**Application for an Order granting Development Consent for the A303 Amesbury to Berwick Down
Written Representation on behalf of Philip Sawkill, Tenant of West Amesbury Farm to comply with Deadline 2 imposed by the Examination Authority**

**STATUTORY PUBLIC CONSULTATION RESPONSE TO A303 STONEHENGE AMESBURY
TO BERWICK DOWN CONSULTATION BOOKLET DATED FEBRUARY 2018
ON BEHALF OF
WEST AMESBURY FARMS, WEST AMESBURY FARM, SALISBURY, WILTS**

**CONSULTATION RESPONSE TO SUPPLEMENTARY CONSULTATION BOOKLET
A303 JULY 2018
ON BEHALF OF
WEST AMESBURY FARMS WEST AMESBURY FARM SALISBURY WILTSHIRE**

Plan that illustrates the distance between Park Farm, West Amesbury in the west to Fox Farm, Amport in the east

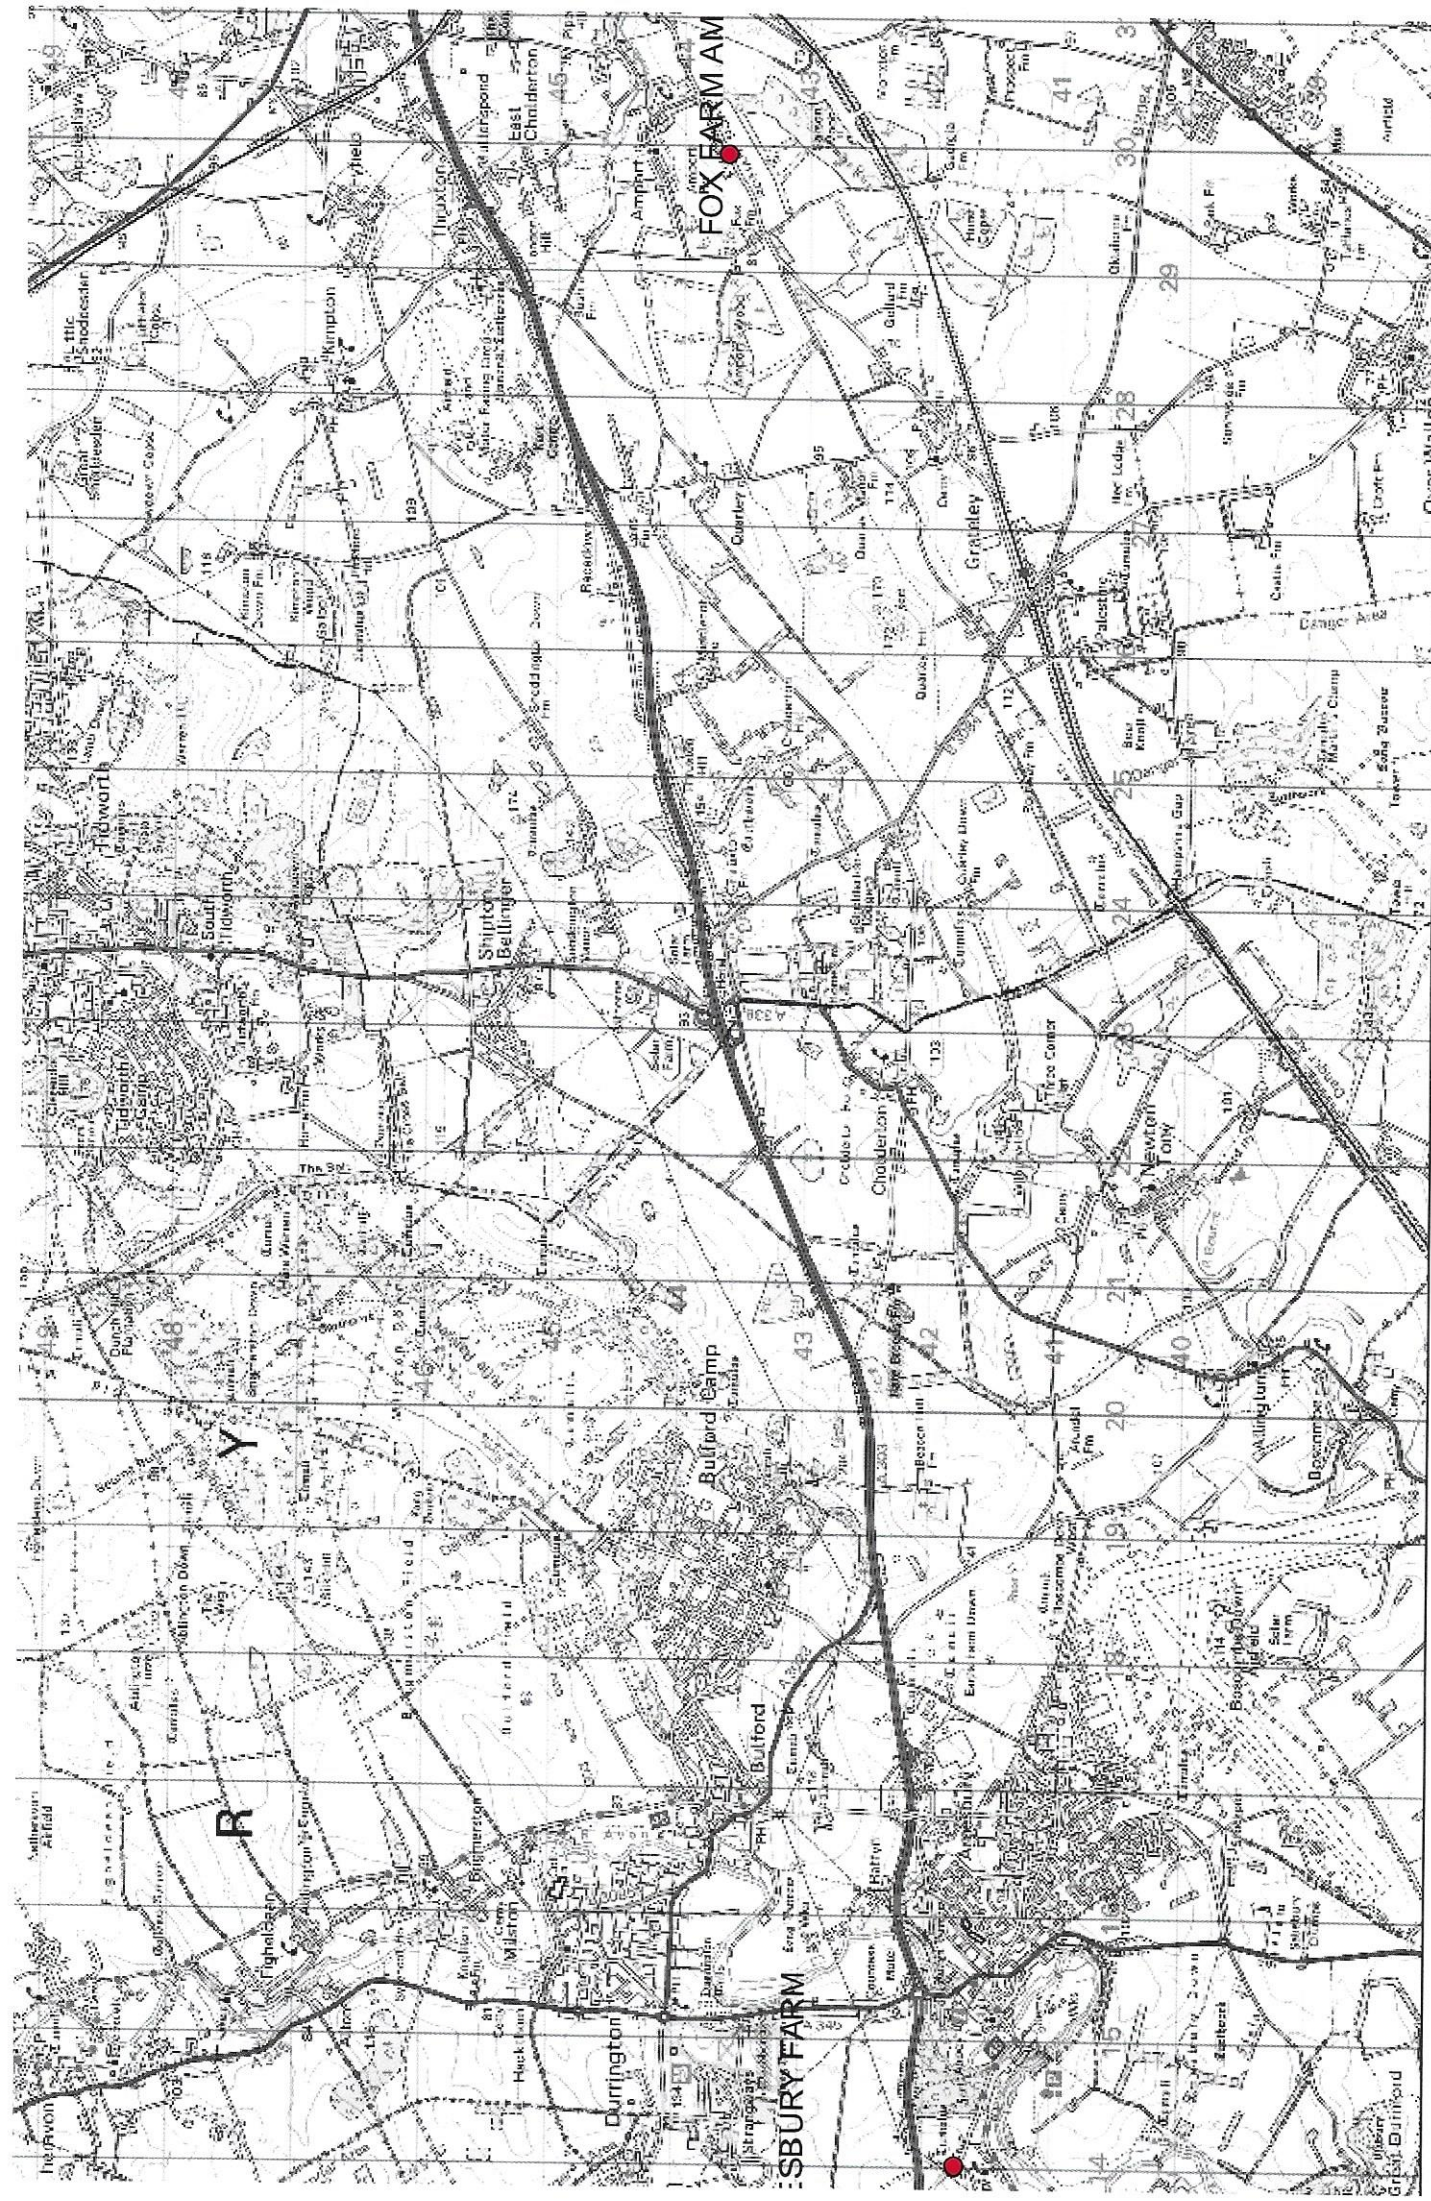
I have proved and it is accepted that my Combine Harvester is unable to manoeuvre through Amesbury as previously suggested which determines that access through Countess Farm to the Countess Road is a necessity. If I do not get access to the Countess Road this will have severe untold consequences on my business as I would not be able to farm in hand land at Stockport Farm, Amesbury or undertake the contract farming arrangements at Fox Farm, Ampport. A plan showing the respective locations of the areas farmed appears at Annex C.

ANNEX E
Plan showing where Stonehenge Road should be closed at its junction with Woodford Valley Road

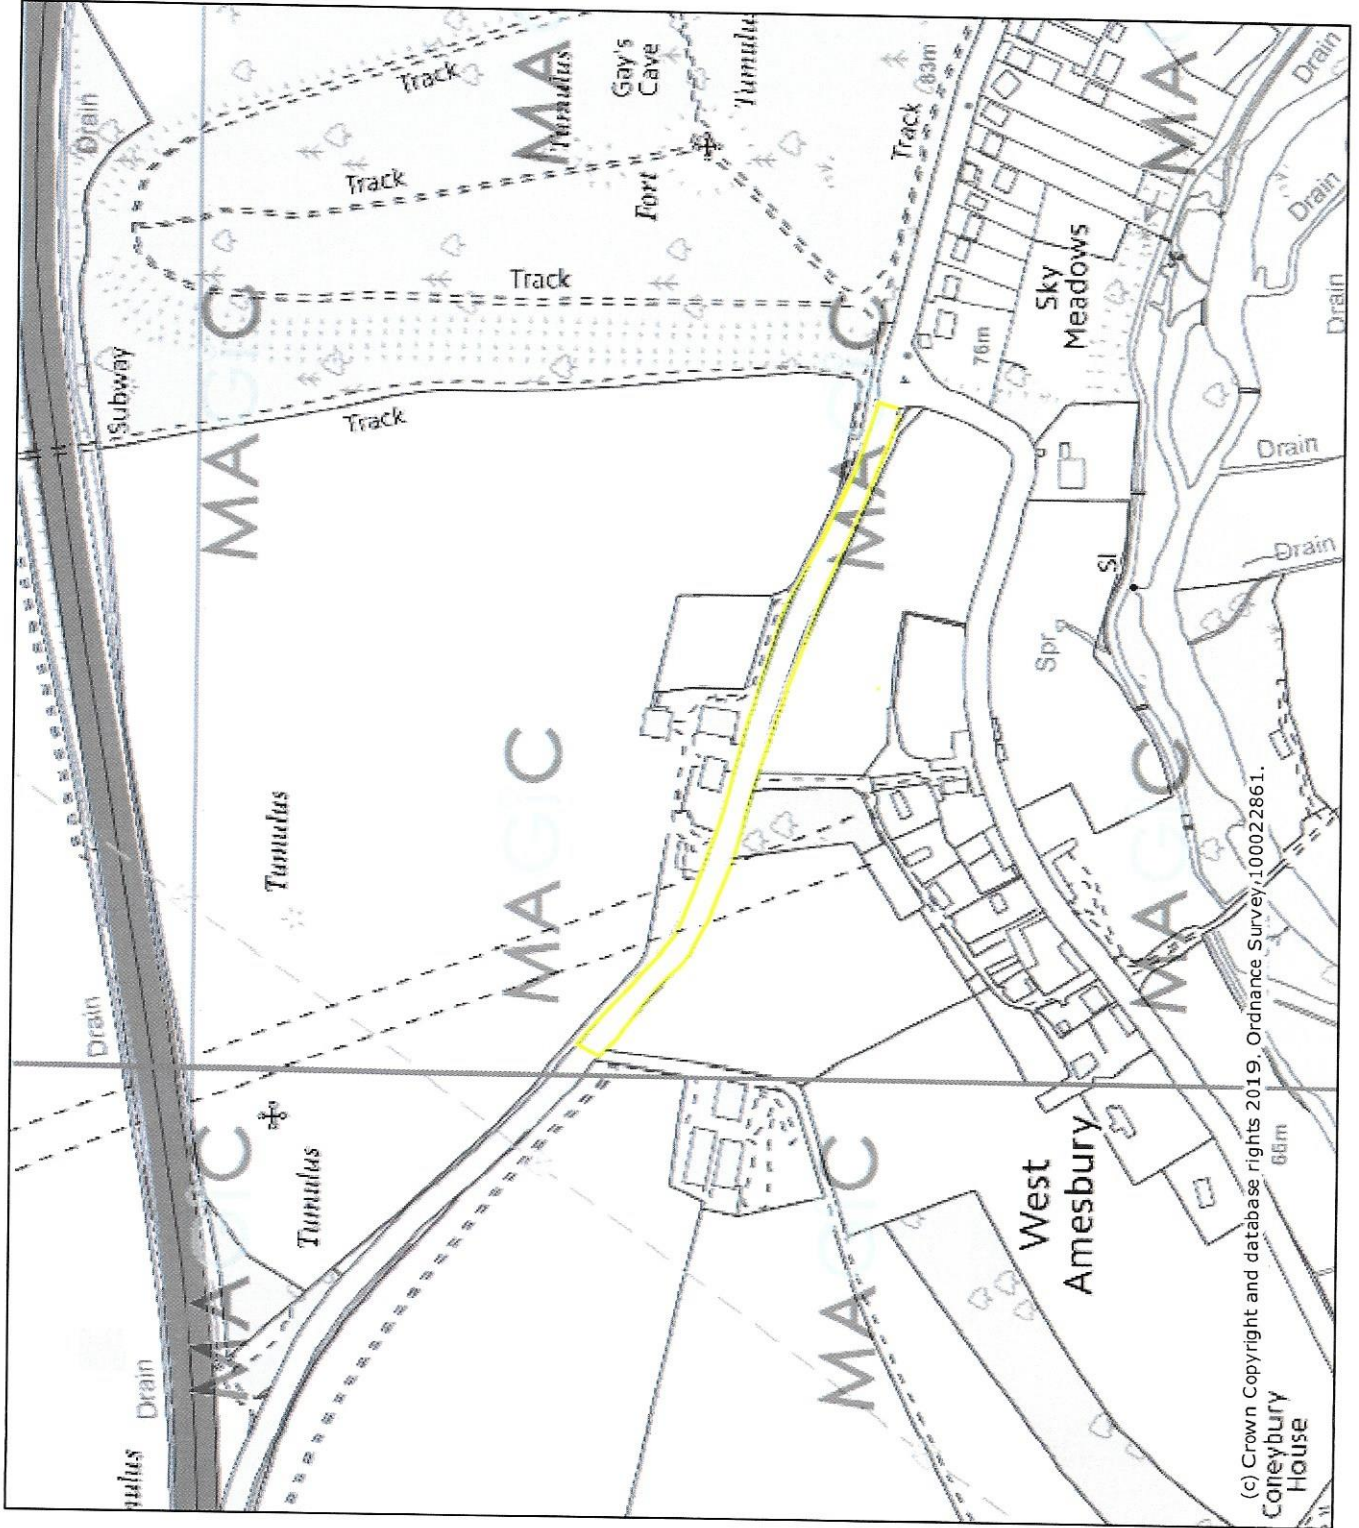
The applicant's proposals for the closure of Stonehenge Road at the location shown on the DCO plans also requires examination as the point of closure is by the main entrance to West Amesbury Farm.

With Stonehenge Road at that point still being a public highway but with no final destination I believe that this area of Stonehenge Road will be used extensively for improper use including fly tipping, parking and camping together with other anti-social uses. This will also substantially increase the risk of the potential illegal activities occurring at West Amesbury Farm. At the same time the risk of potential incidences surrounding livestock which are housed at West Amesbury Farm and Park Farm being potentially in conflict with members of the public is increased and if the intended closure point of Stonehenge Road was moved to the Woodford Valley Junction this also diminishes the risk of farm livestock being subject to theft.

A suggestion has been made to Highways England that the point of closure of Stonehenge Road should be at the junction of the Woodford Valley Road which is shown on the attached plan at Annex E. The intended use of the declassified section of Stonehenge Road would not be altered and the owner of Park Farm has offered to assume maintenance for this area, as the principal affected land owner and user. Between the owner of Park Farm Cottages and myself as tenant of West Amesbury Farm we would then have the ability to "control" and maintain that area to our standards rather than have to rely on Wiltshire Council and their diminishing funds. Highways England should examine the applicant as to why no alternative to the proposed closure point of Stonehenge Road has been considered or put forward as a viable alternative.
